Memorandum

To: David Lloyd
From: Mike Nugent/Inspections Division Director
Date: 5/23/2005
Re: Winslow Lofts (037 C017)

I have commenced the review of the building plans and require the following or have the following questions:

A1

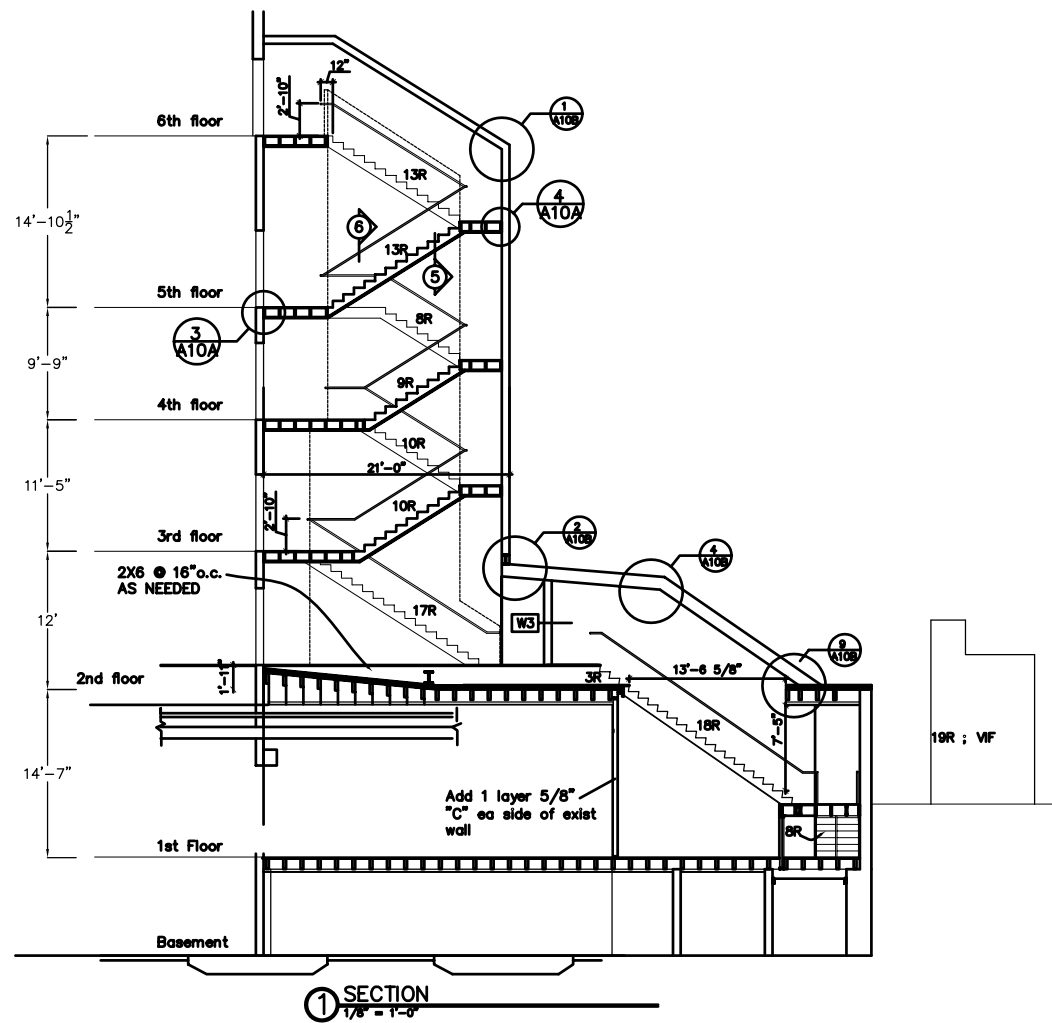
- 5) First floor right second means if egress is through and unassigned room, this may conflict with Section 1013.2. Please provide a code justification.

- 8) No handrails are shown on the "rear stairway" on A1 and A2. (and other floor plans) Does the Typical on A10.A provide us with the assurance that all stairways will have code compliant handrails?

A10A

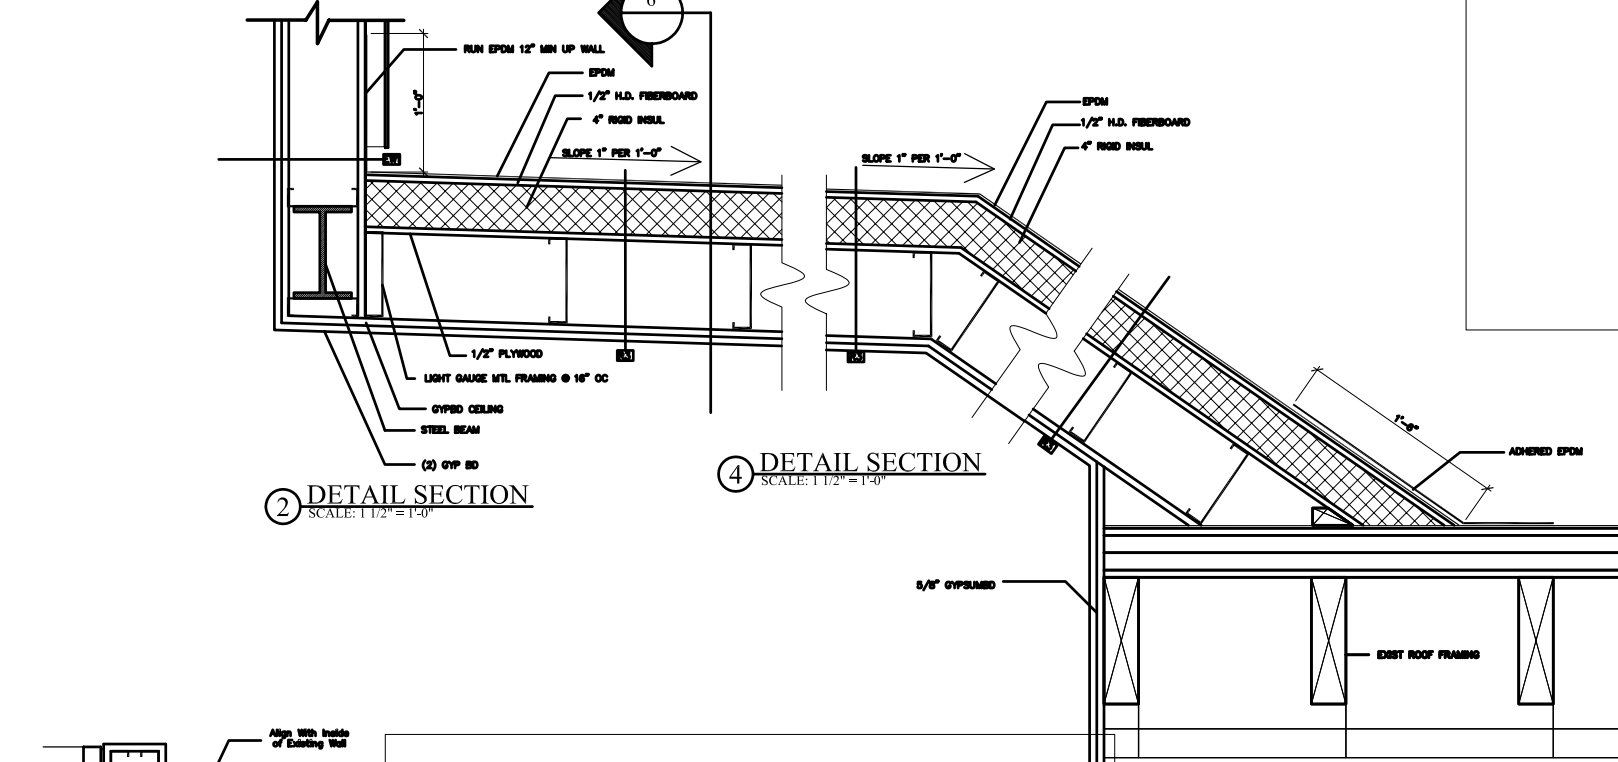
- 3) A.10.A figure 1. Please make sure that the first stairway does not exceed 12 feet from landing to landing.
- 4) Need the Sound transmission classifications for the Floor Ceiling and Party wall assemblies and well as the assemblies that separated the D/U's from the common areas.
